From: Planning
Sent: 16 January 2020 16:19
To: DC Support
Subject: FW: Great Wolf - Arboriculture

Reviewing the Arboricultural Impact assessment from desk based assessment.

DRAWING No: 70058541-TPP-EV-003	REV: P02
------------------------------------	-------------

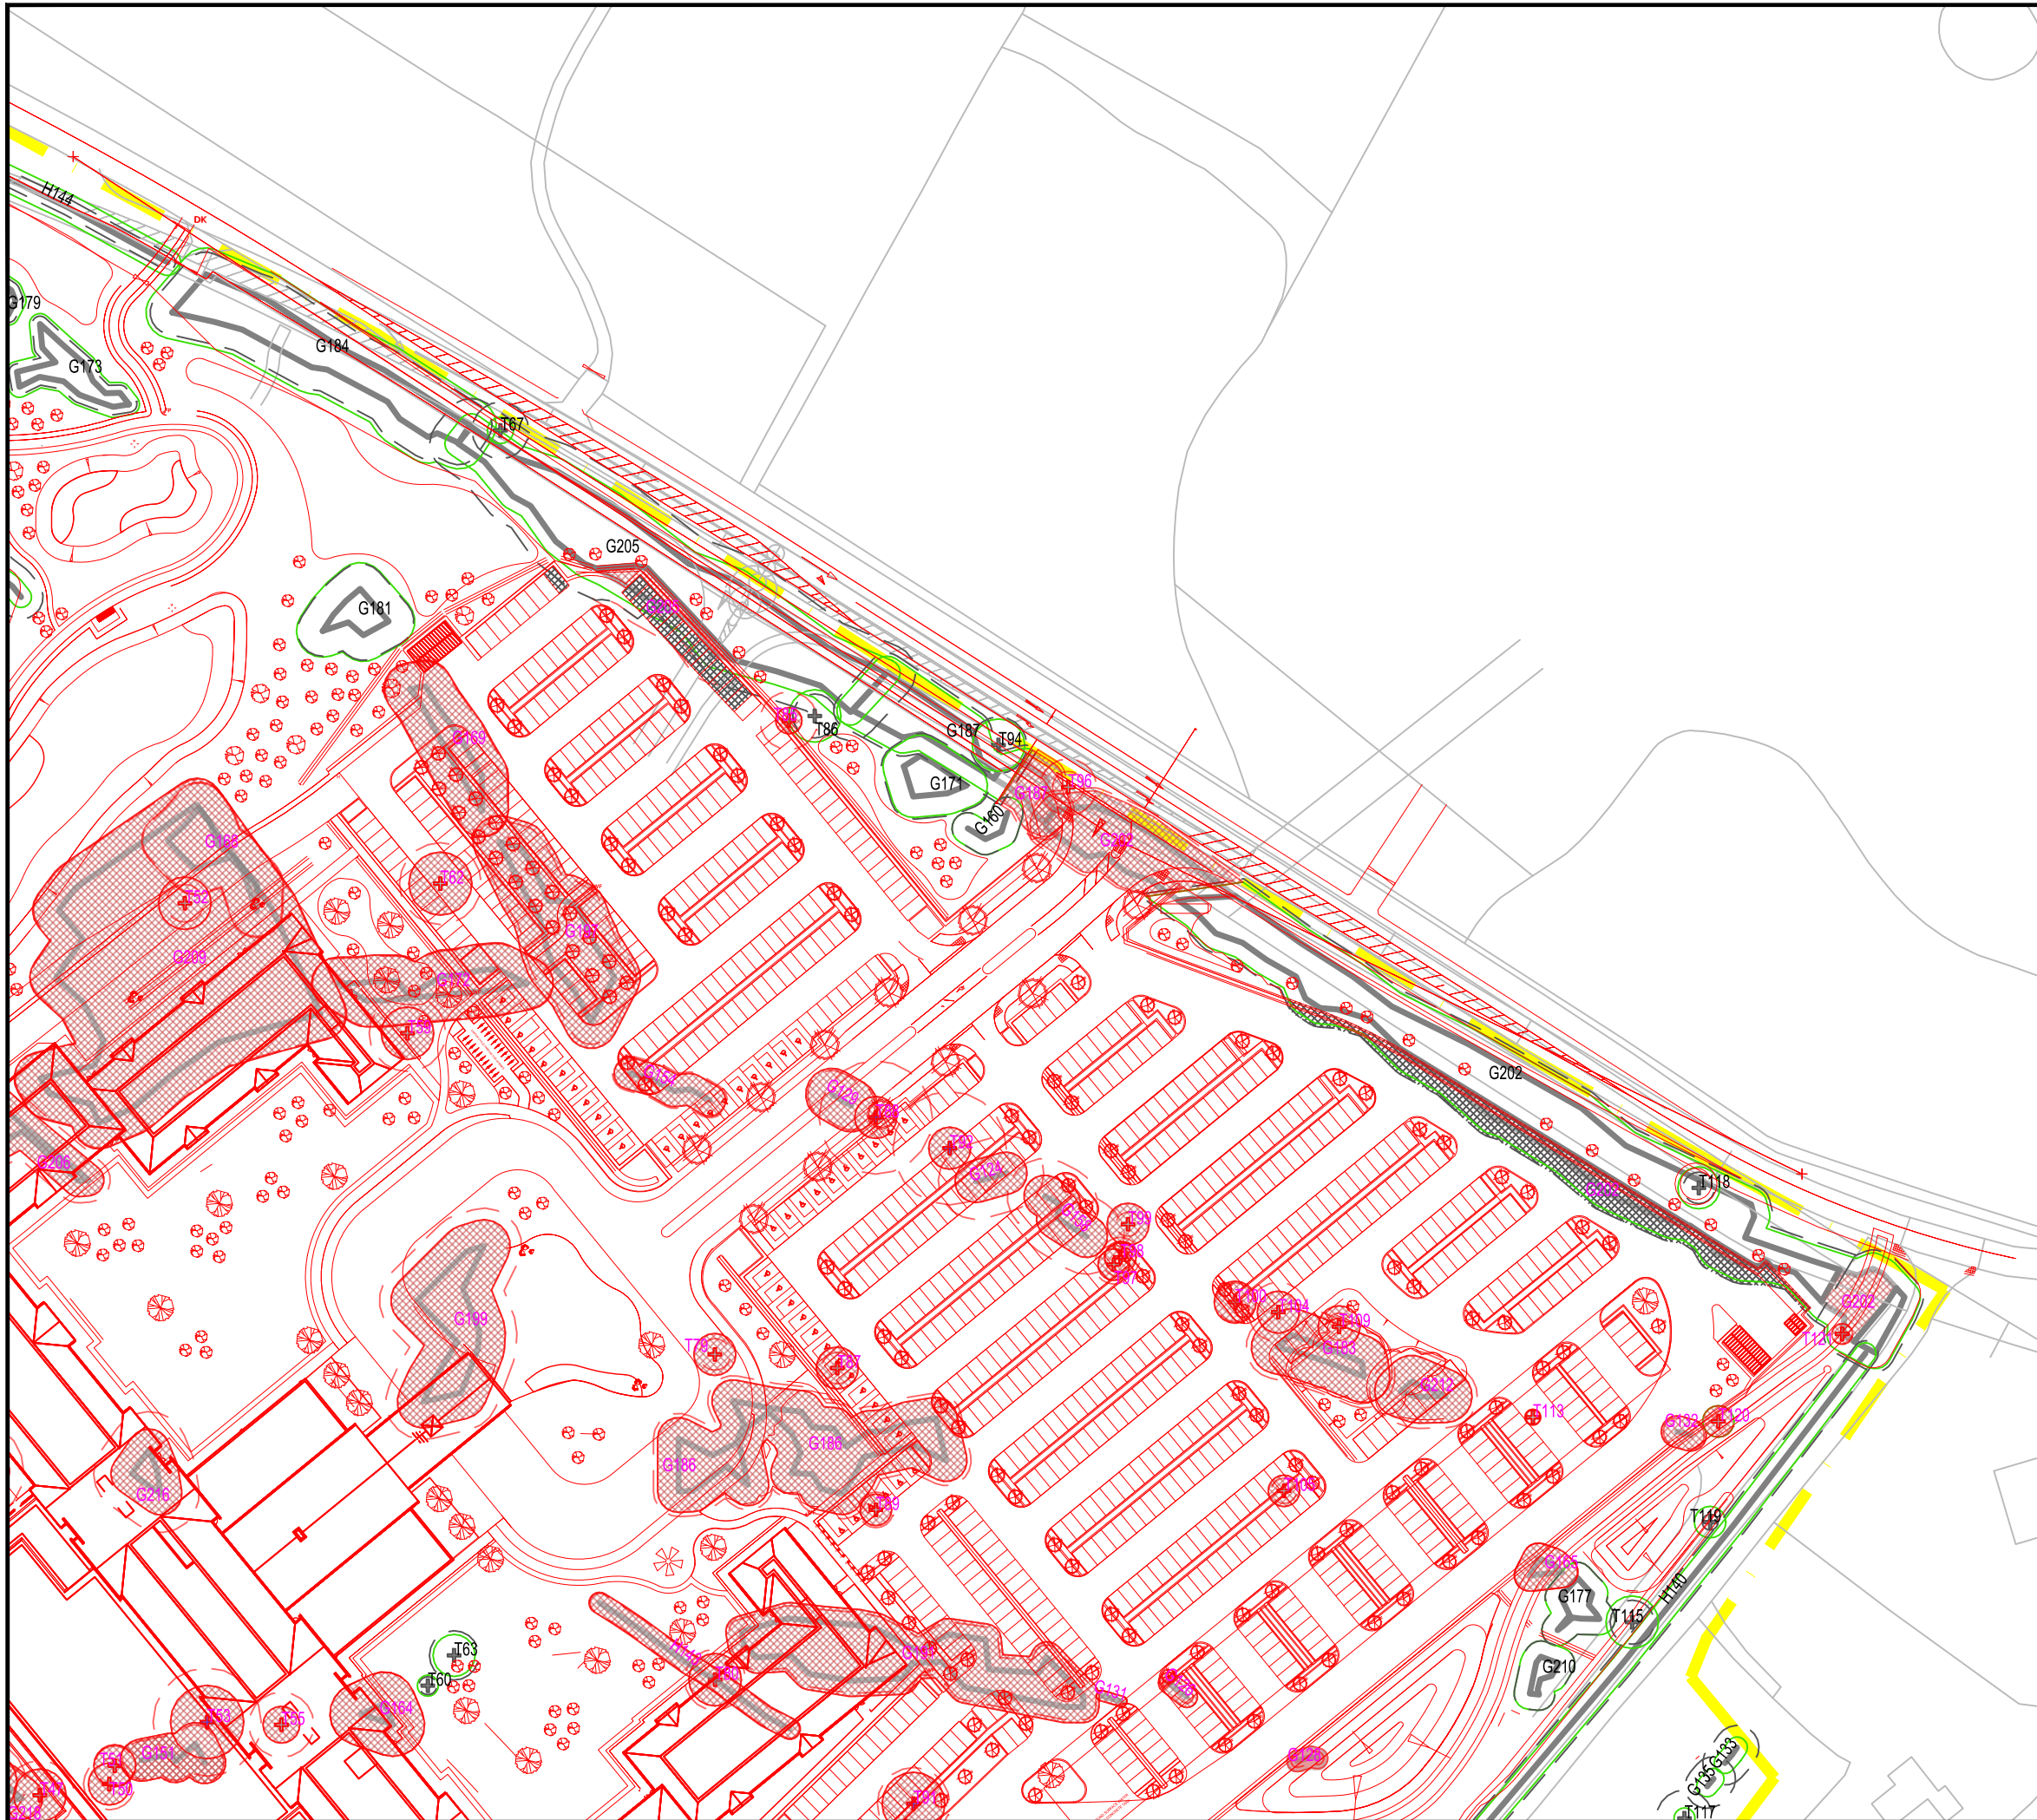
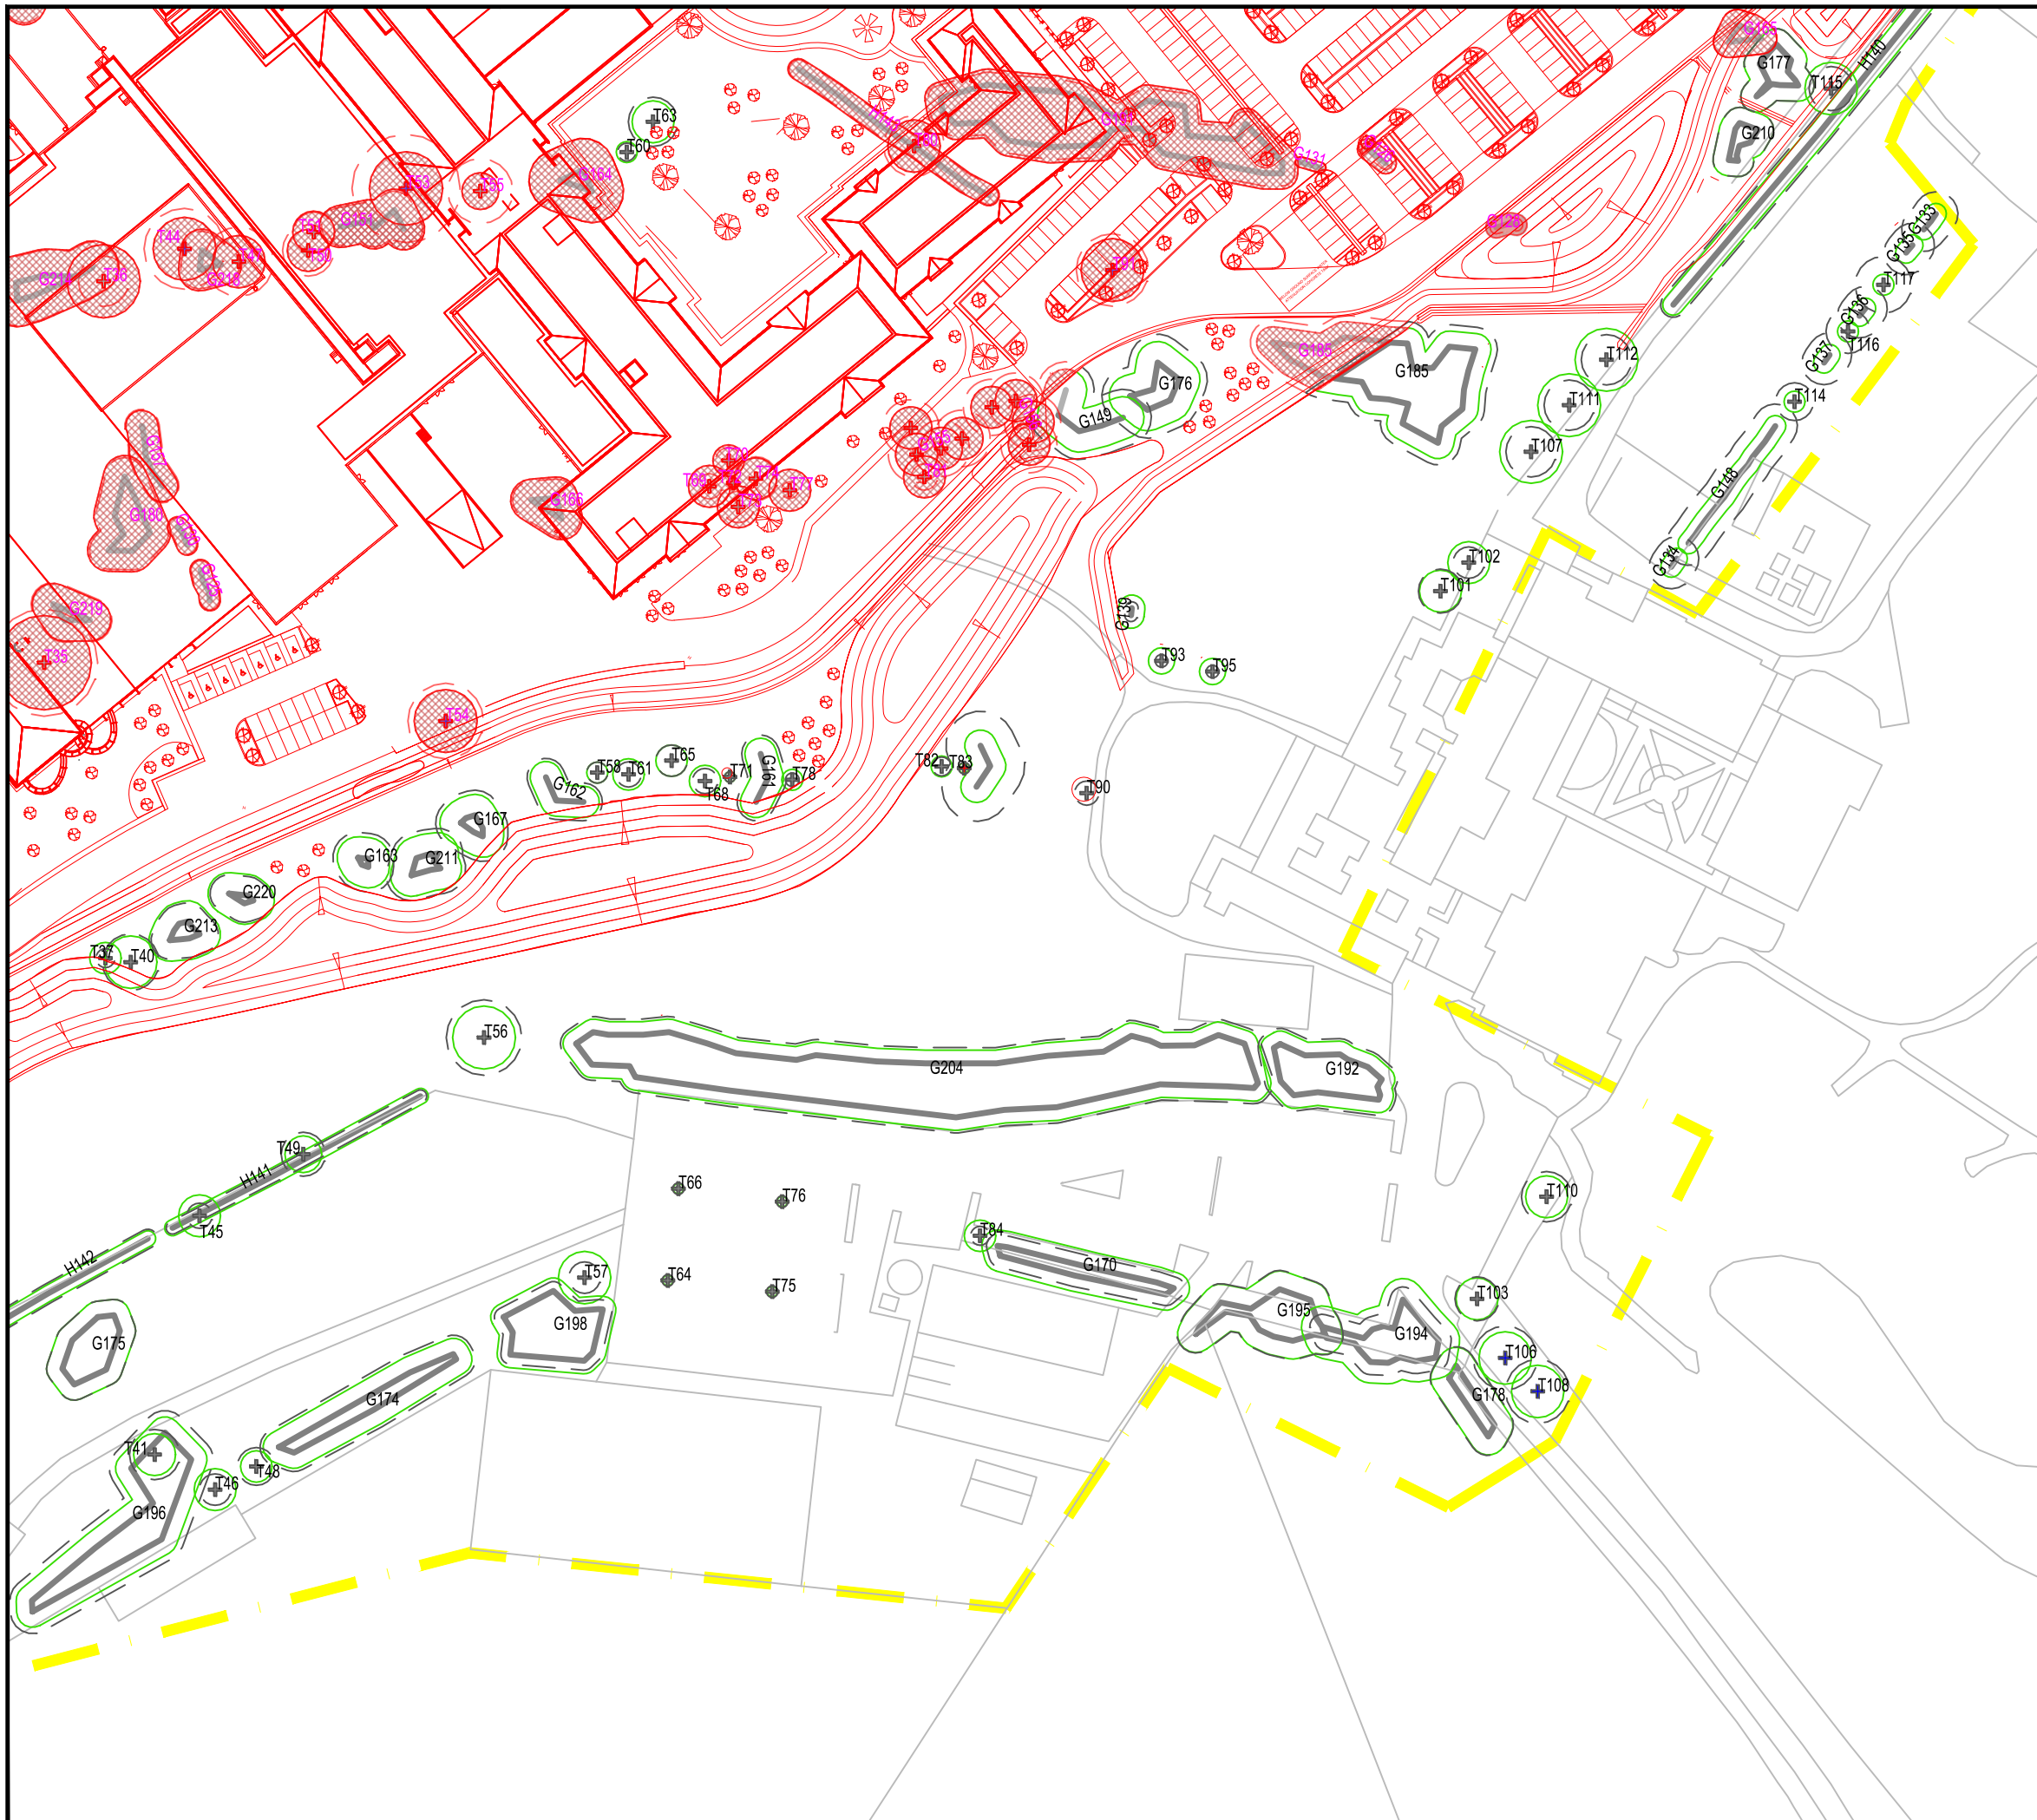
Retained trees appear to have been considered, and appropriate protective measures demonstrated. TPO no.1 1991 will require review, however in principle it is accepted the condition of the trees included in 1991 are likely to have changed, therefore their appropriateness for continued protection may also require review.
